WEST SUSSEX COUNTY COUNCIL CONSULTATION

TO:	Arun District Council FAO: A Gardner / A Wood
FROM:	Highways, WSCC
DATE:	3 rd December 2018
LOCATION:	32 & 34A, Sea Lane, Ferring, West Sussex, BN12 5DY
SUBJECT:	FG/183/18/DOC Application to discharge conditions imposed on planning reference FG/174/17/PL relating to condition 3 - Construction management plan & condition 5 - Surface water drainage. More information.
RECOMMENDATION:	☒ Advice ☐ Objection ☐ Modification ☐ No Objection ☐ More Information ☐ Refusal
S106 CONTRIBUTION TOTAL:	£N/A

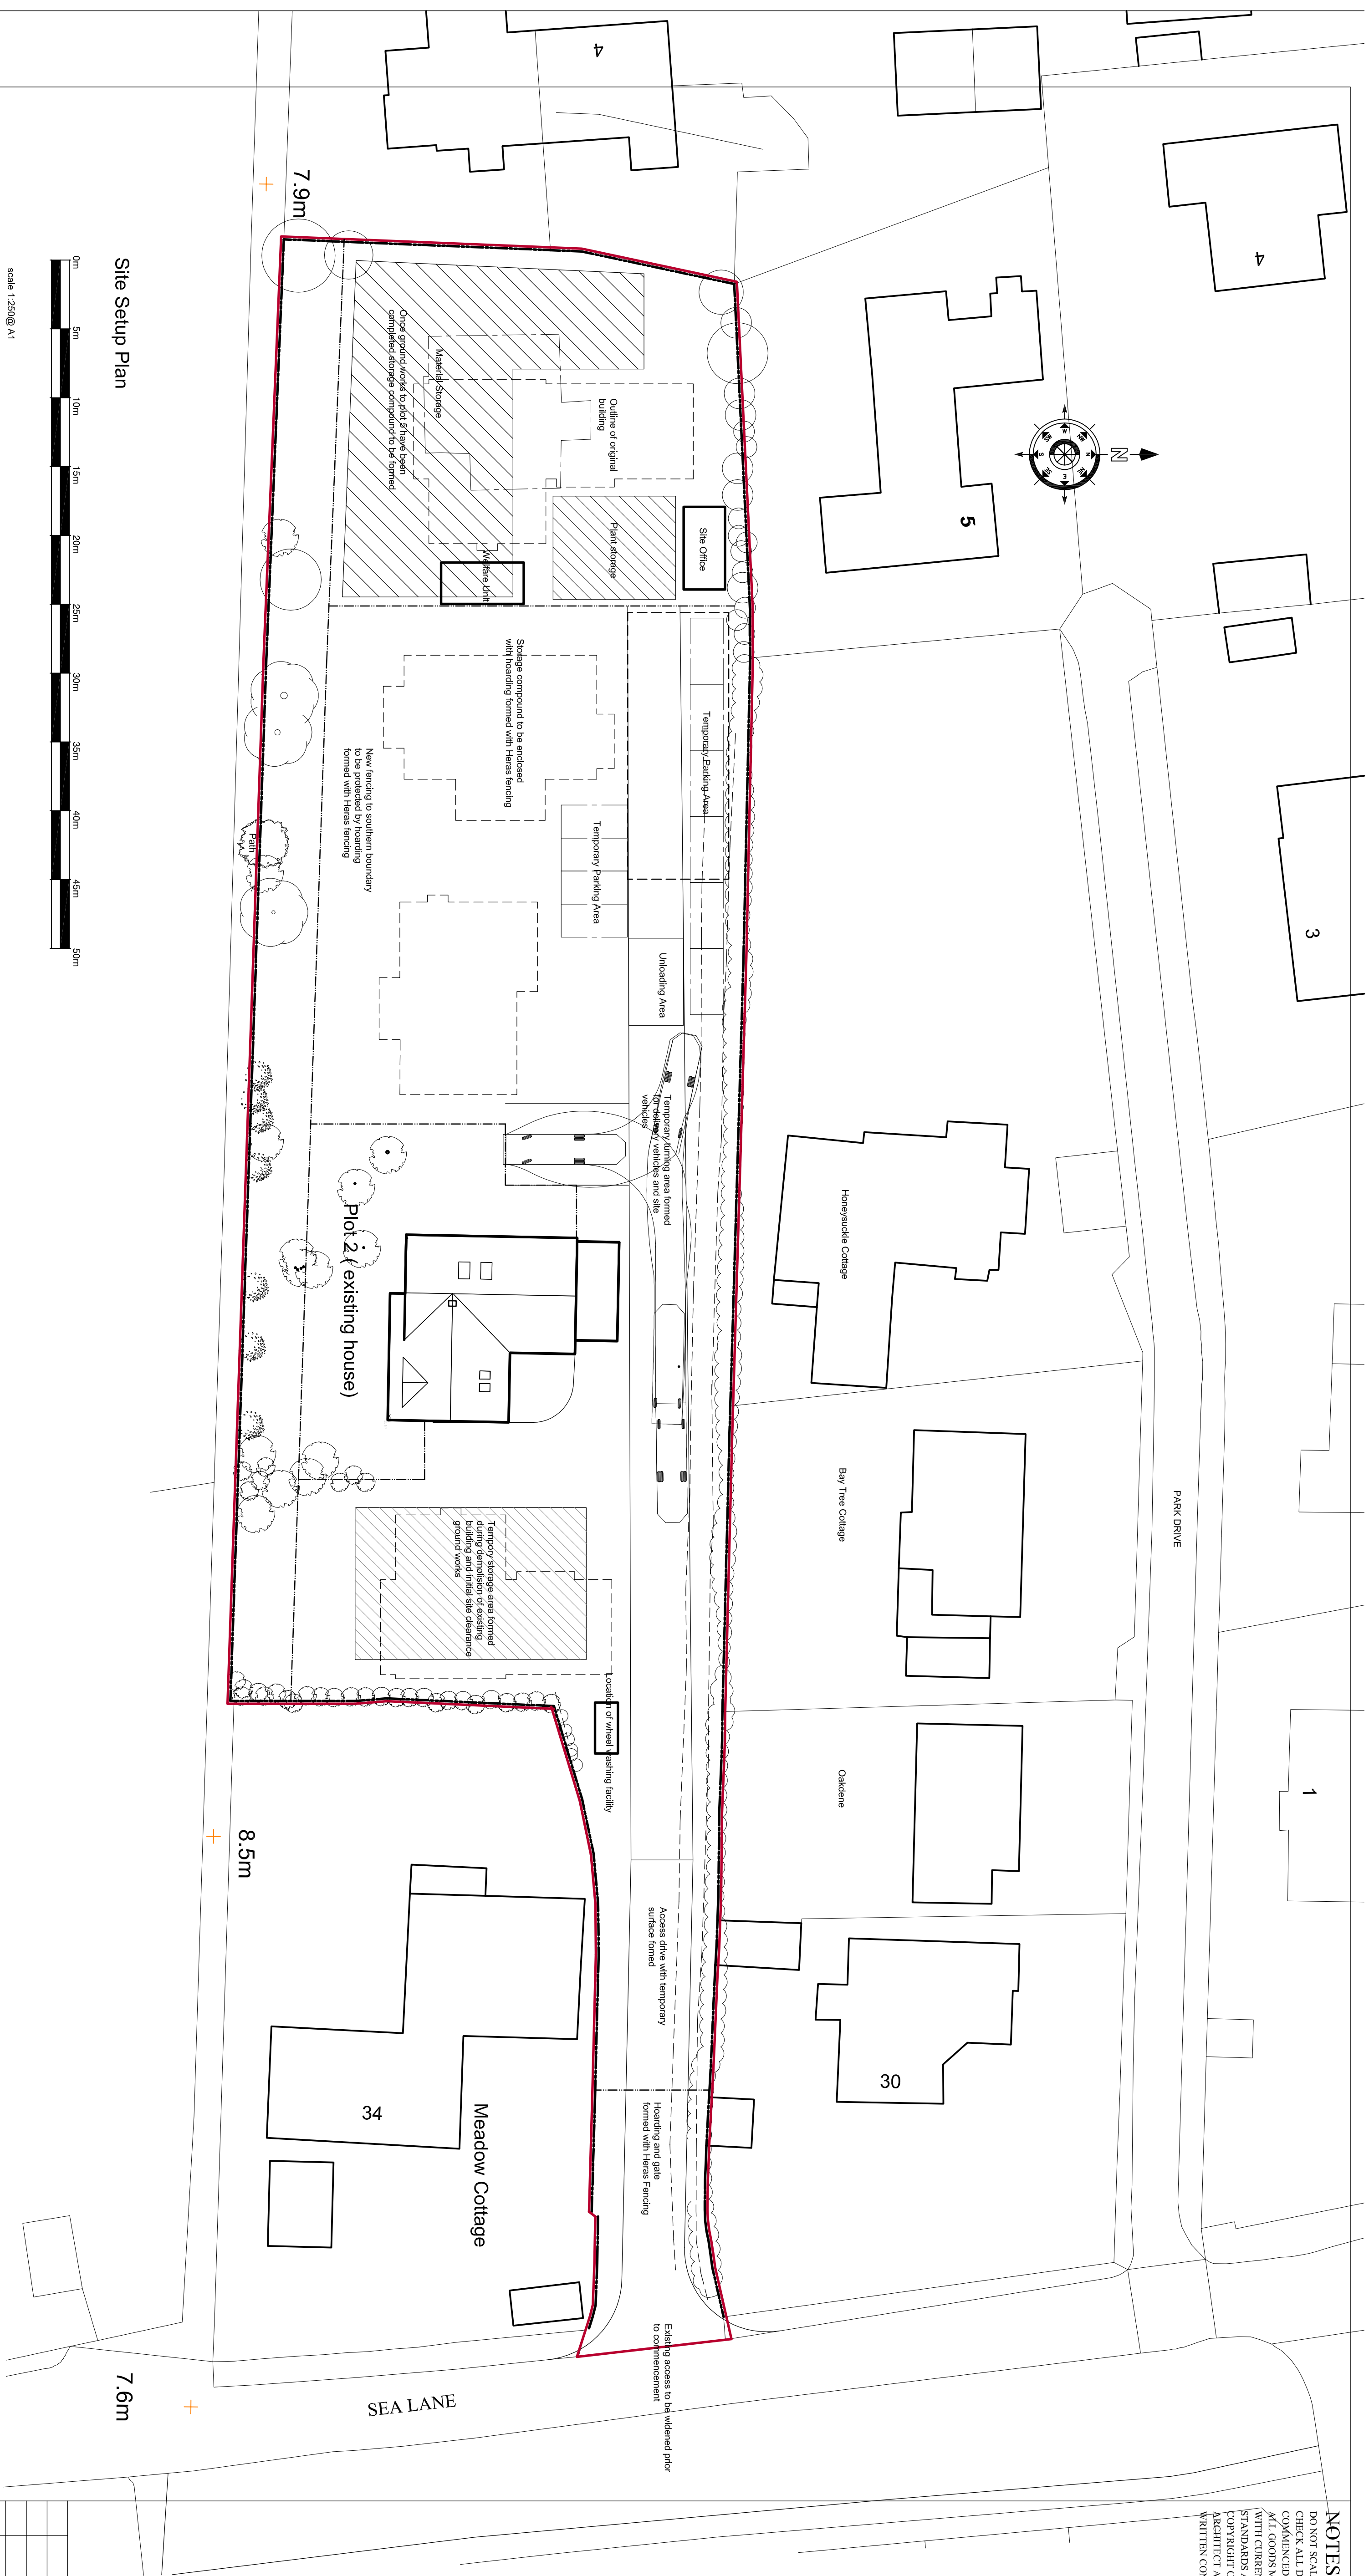
A Site Set-Up plan has been provided which details areas on site for material and plant storage, temporary contractor parking, vehicle turning and unloading area and wheel washing facility.

The access will be widened prior to commencement to allow the type of construction vehicles anticipated to access the site. Swept path tracking has been demonstrated within the site. Although the swept path has not been shown from the public highway access in to the site, this has been demonstrated on previous applications at the site for a fire tender. The applicant is reminded that a licence for the access widening works must first be granted from the WSCC Highways Engineer.

The plans and details pertaining to the condition are acceptable.
